Re: 35810/APP/2026/735 - Tavistock Works

Thank you for forwarding the applicant's response. A number of the revisions are welcomed, in particular the move away from the red-toned materials. The following comments respond to that submission and set out the points that remain outstanding or require clarification.

Image 4-1: Cycle Parking Locations

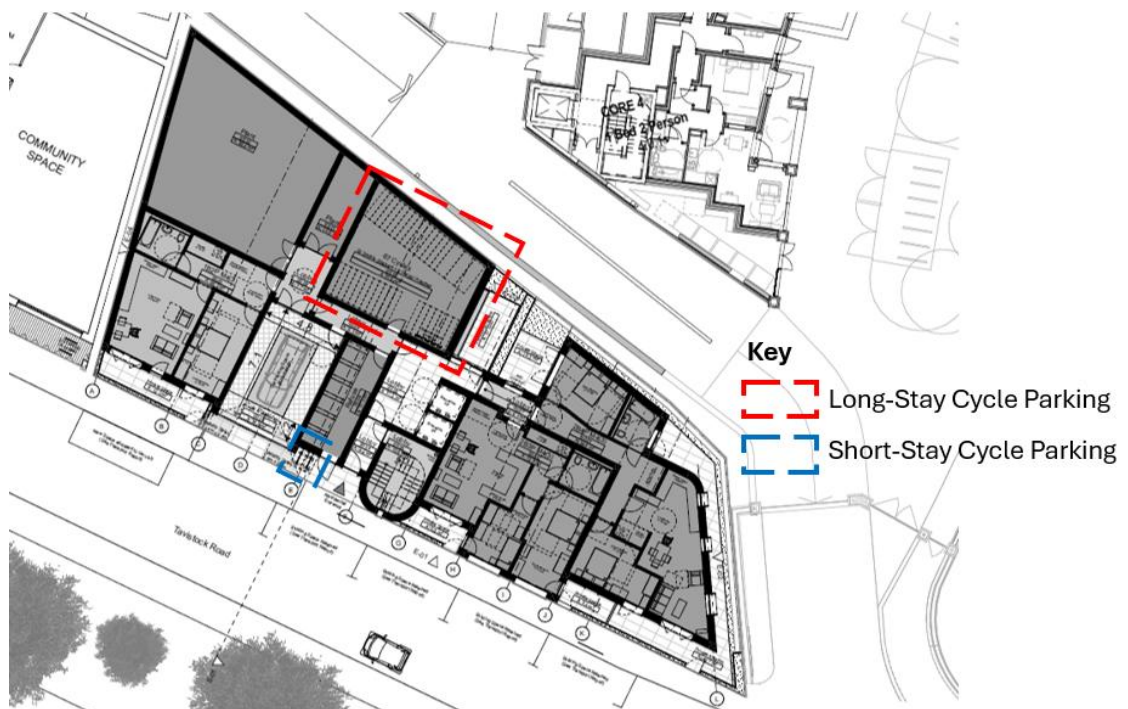
Cycle parking — the cycle stands shown immediately at the entrance are likely to obstruct the entrance approach in practical use, with parked cycles encroaching on the threshold; we would ask that they be relocated or reconfigured so they do not impede or visually clutter the main entrance.
